Flyers Creek Wind Farm MOD 3 Project (MP 08_0252 MOD 3)

I refer to your request to the Environment Protection Authority (EPA) for comment on the Flyers Creek Wind Farm MOD 3 Project (MP 08_0252 MOD 3) that involves a reduction in the number of turbines from 42 to 38, and removal of associated land.

**Loc 12 Background Noise at Receiver vs Wind Speed at Windfarm
78.6m AGL Total Regression**

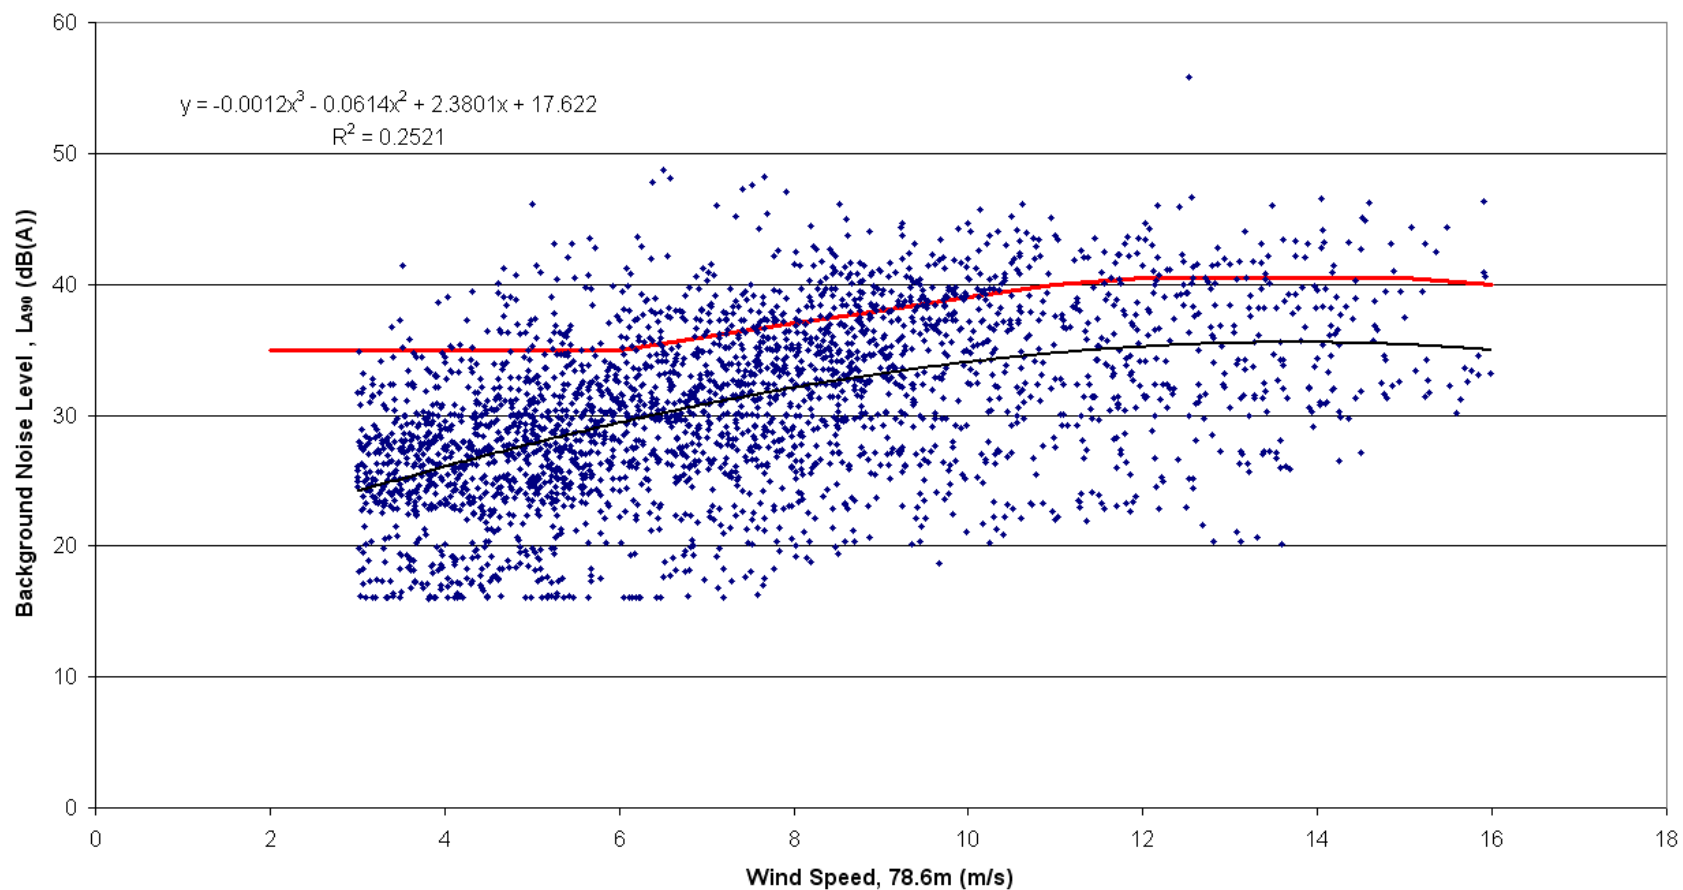
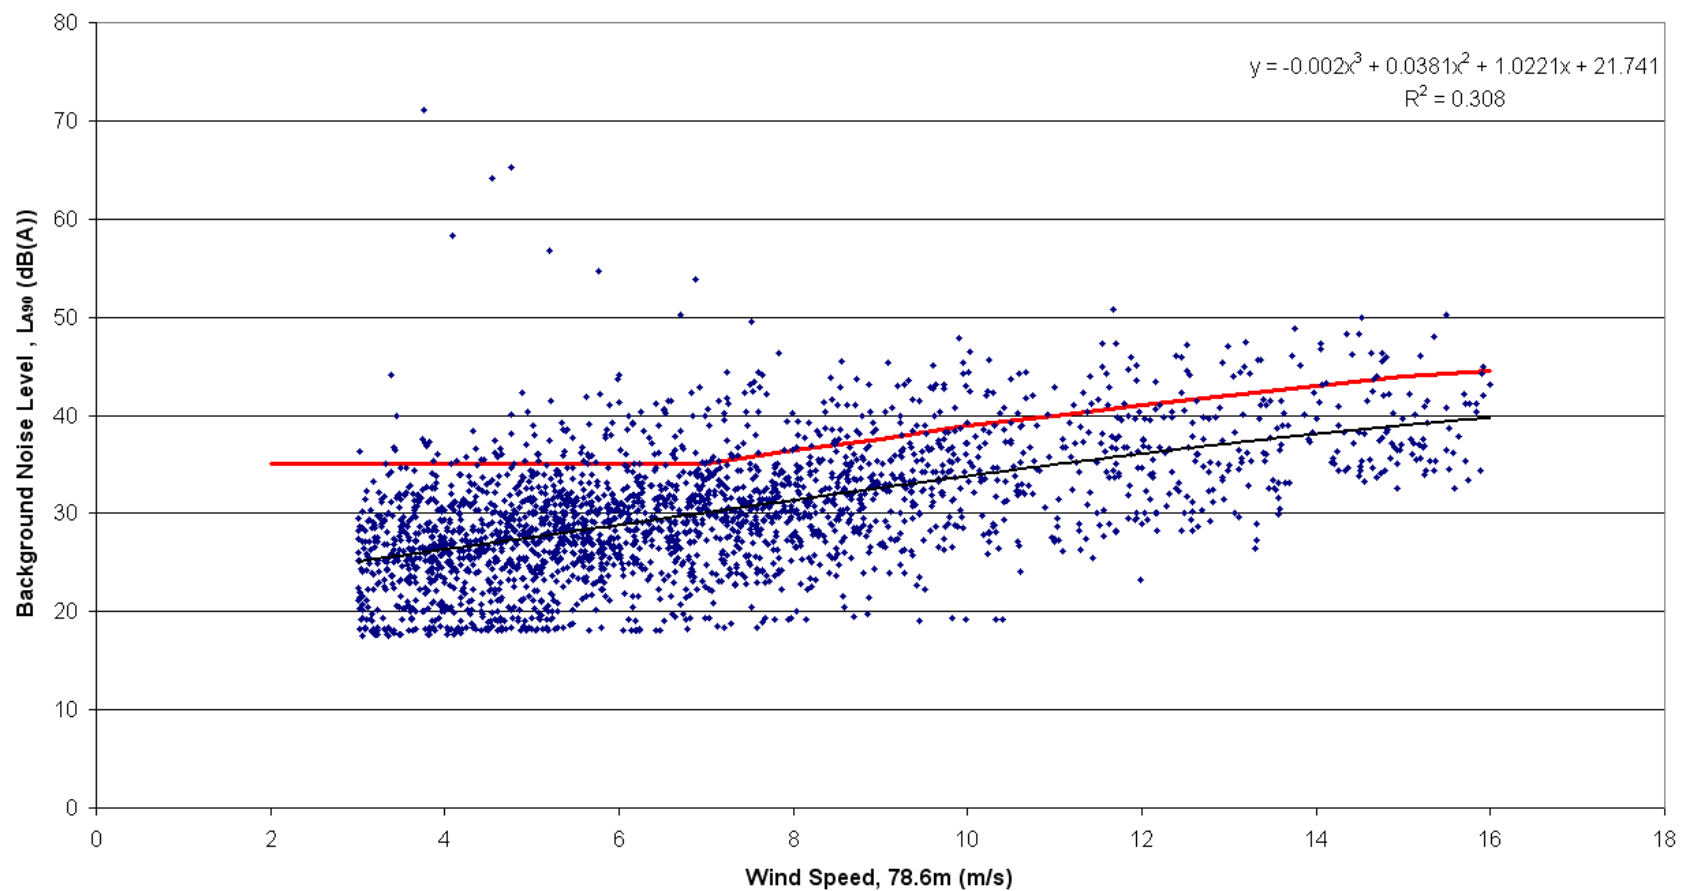
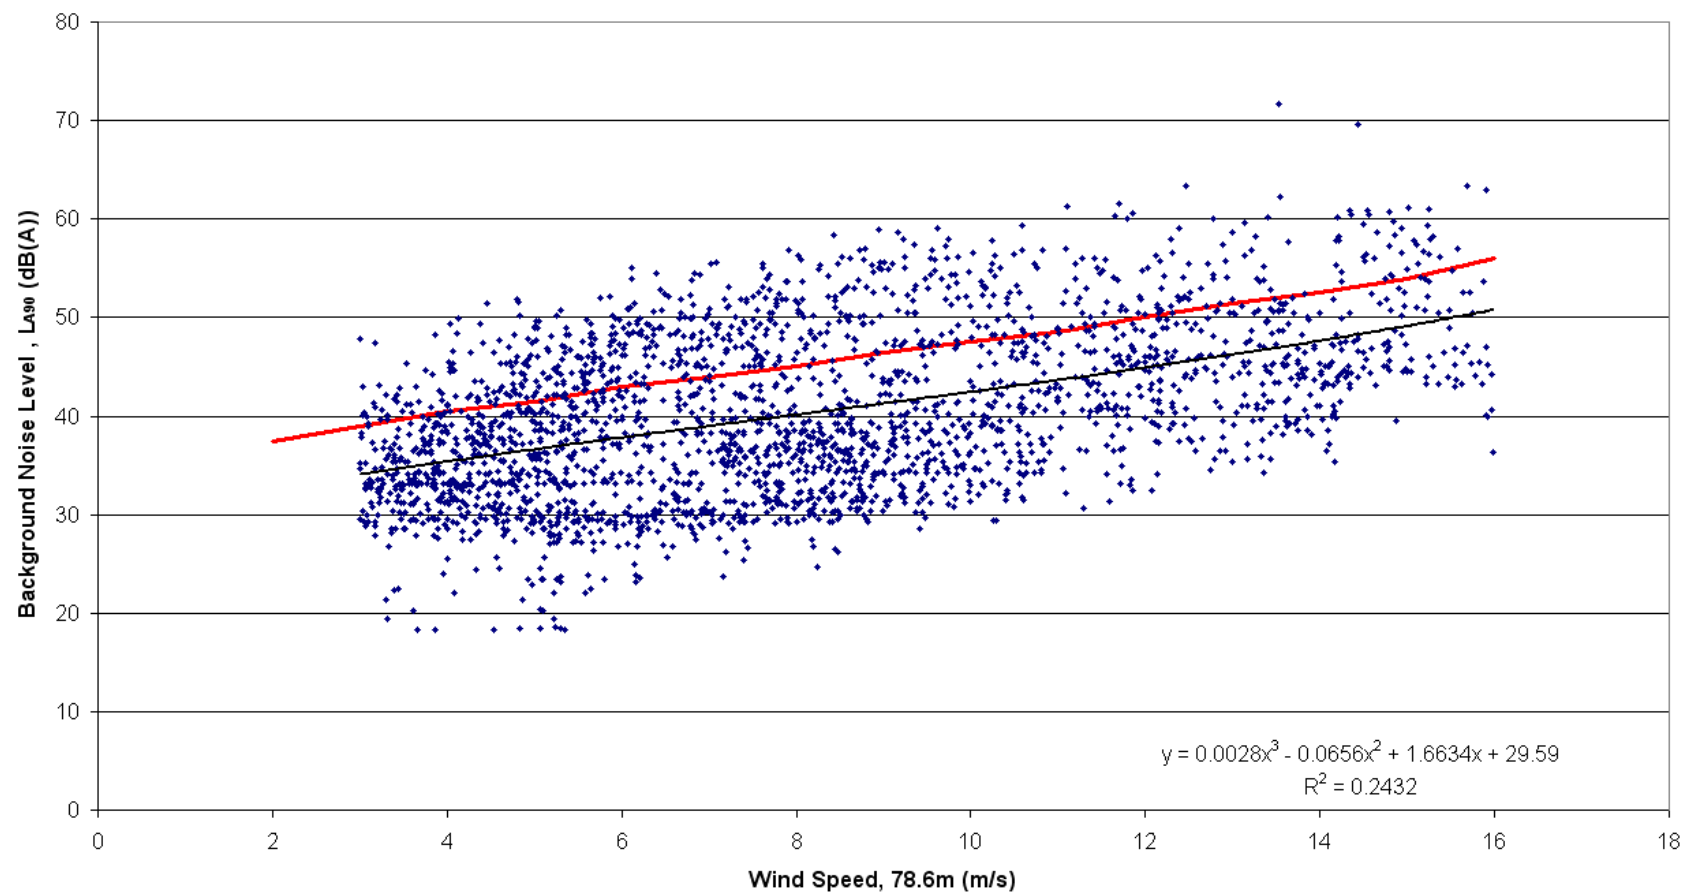
- provide regression equations for background noise from the latest monitoring at locations R12, R25 and R78
- provide noise criteria from the latest monitoring at locations R12, R25 and R78 for wind speeds from 10 m/s to 12 m/s at 10 metres above ground level, or
- explain to the satisfaction of the EPA, why they did not assess wind speeds above 9 m/s at 10 metres above ground level.
